EPC STORMWATER REVIEW COMMENTS
 IN ORANGE BOXES WITH BLACK TEXT

EL PASO COUNTY GRADING AND EROSION CONTROL PLAN CHECKLIST

EROSION CONTROL PLAN

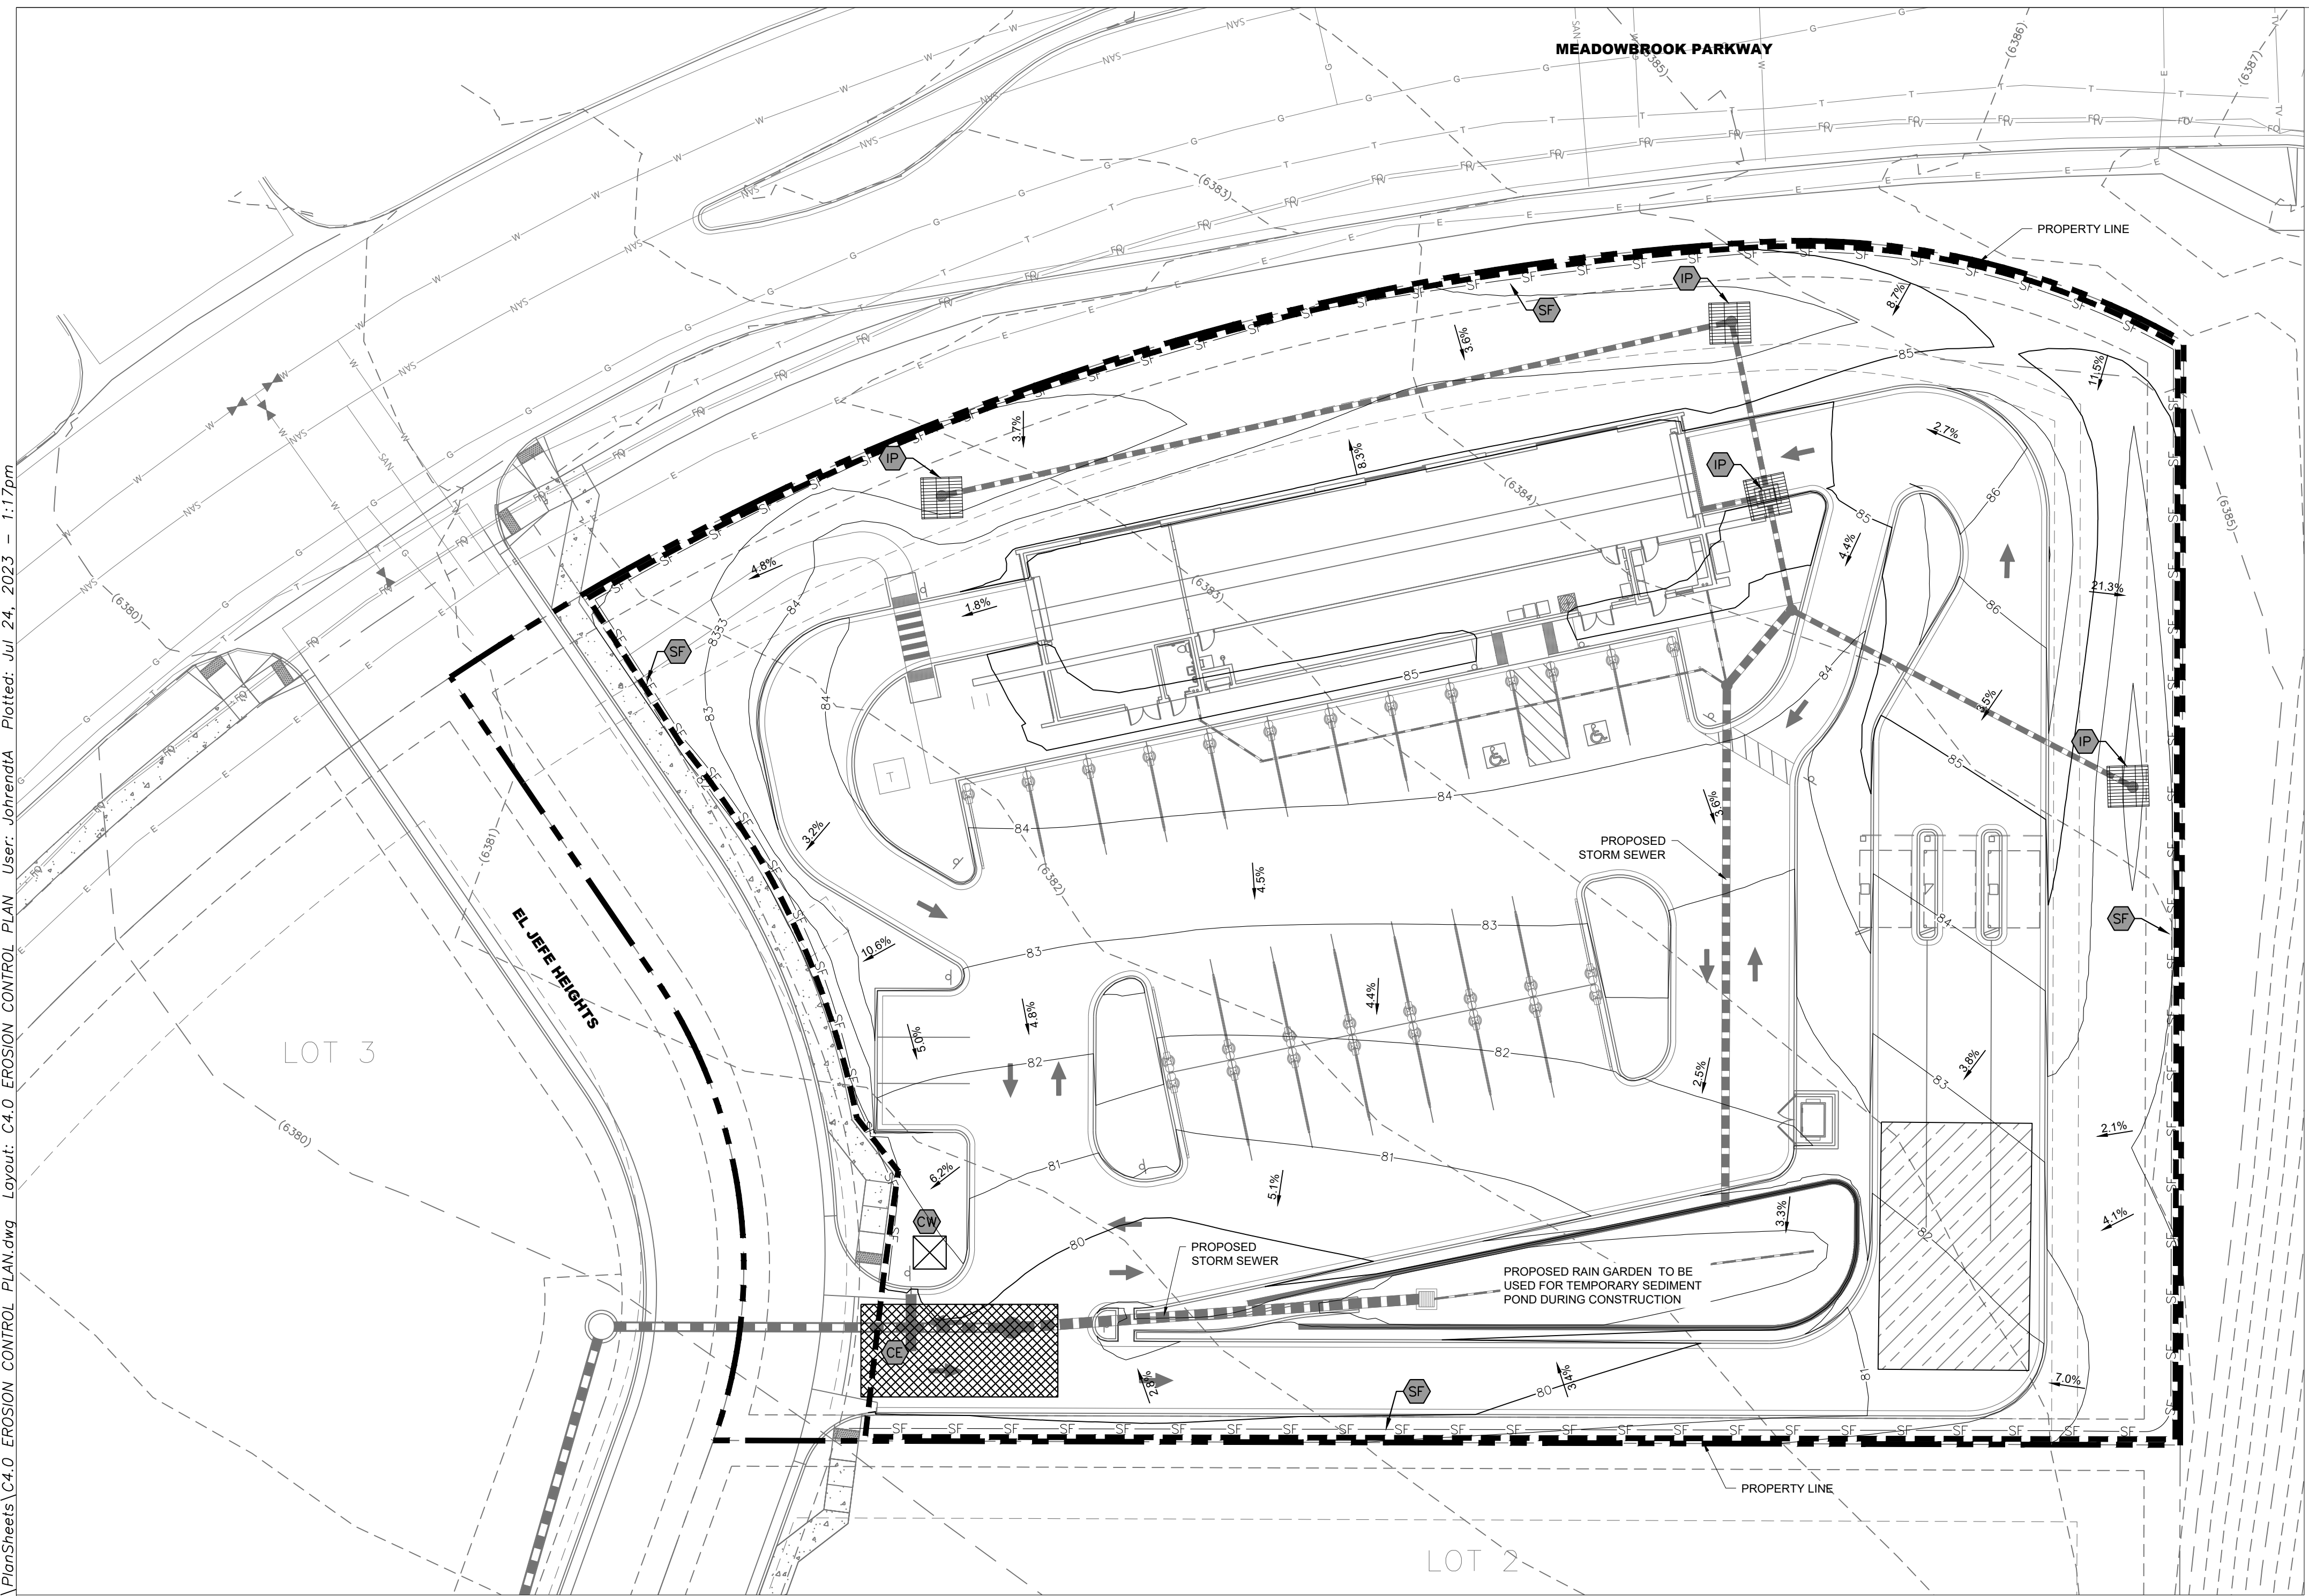
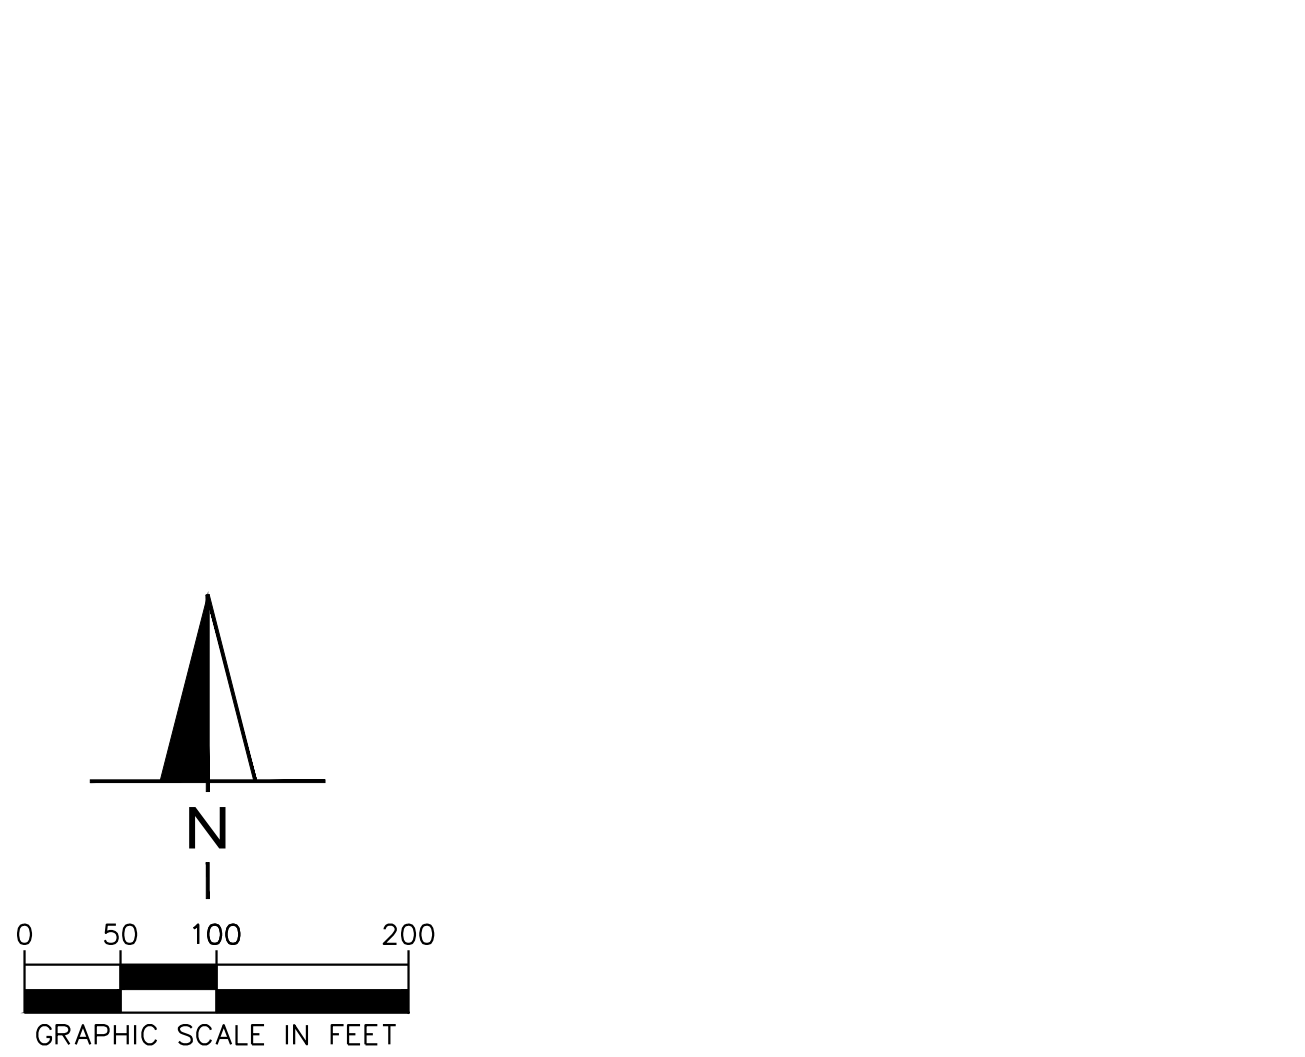
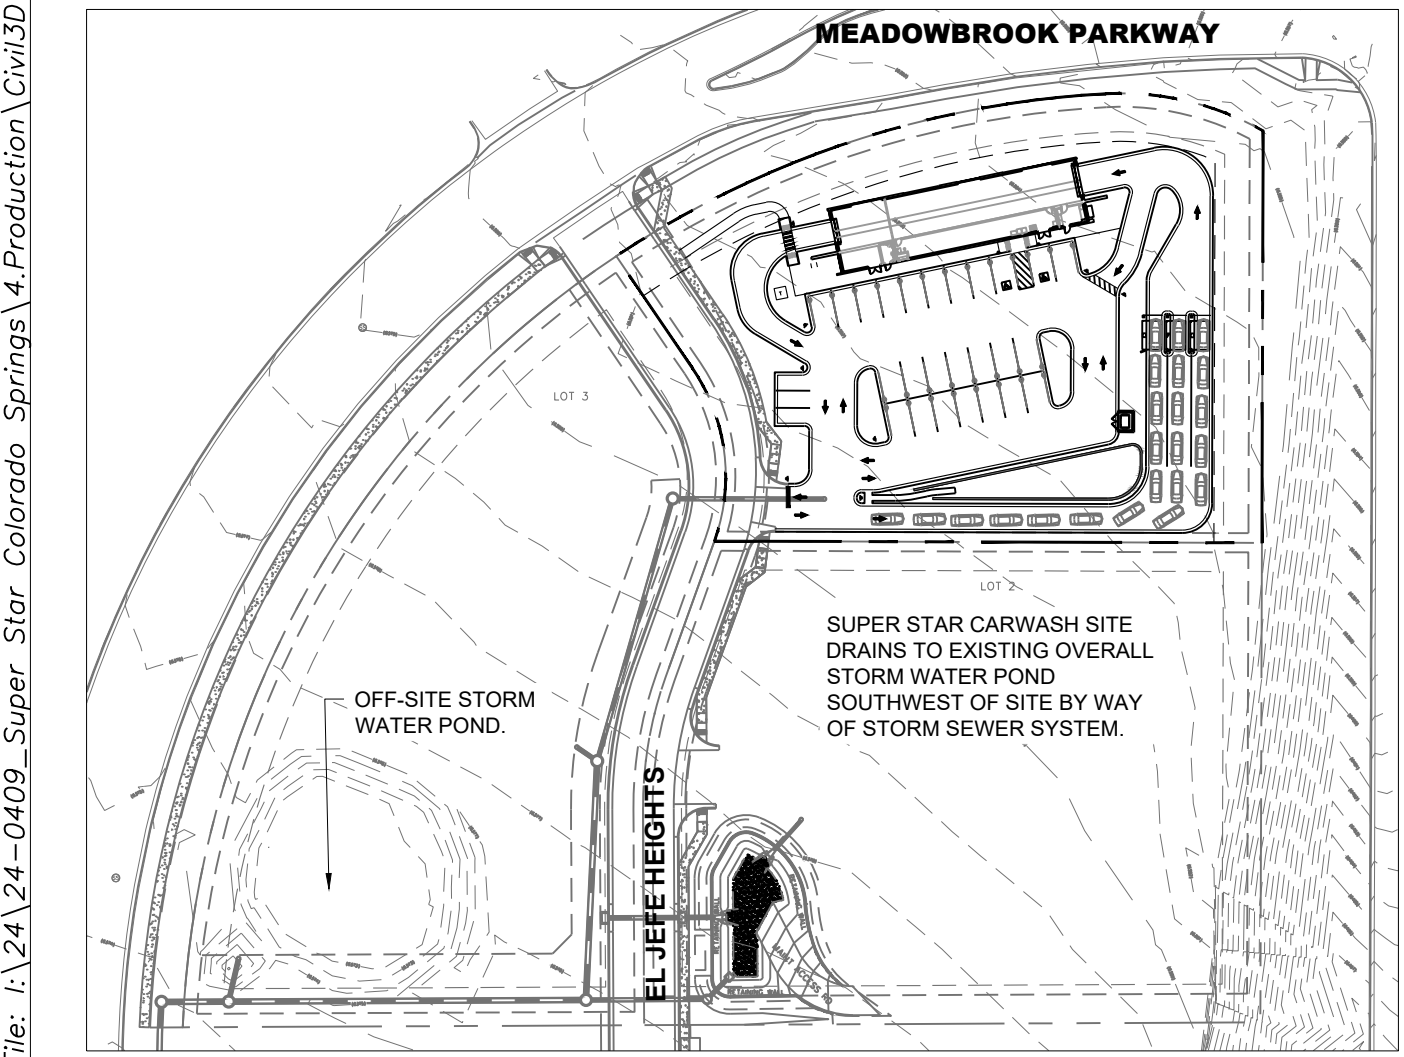
Off-site SW control measures are not on the plans. This should either be N/A or the off-site facilities must be shown and clearly labeled. These facilities must be explicitly discussed in the DR and SWMP.
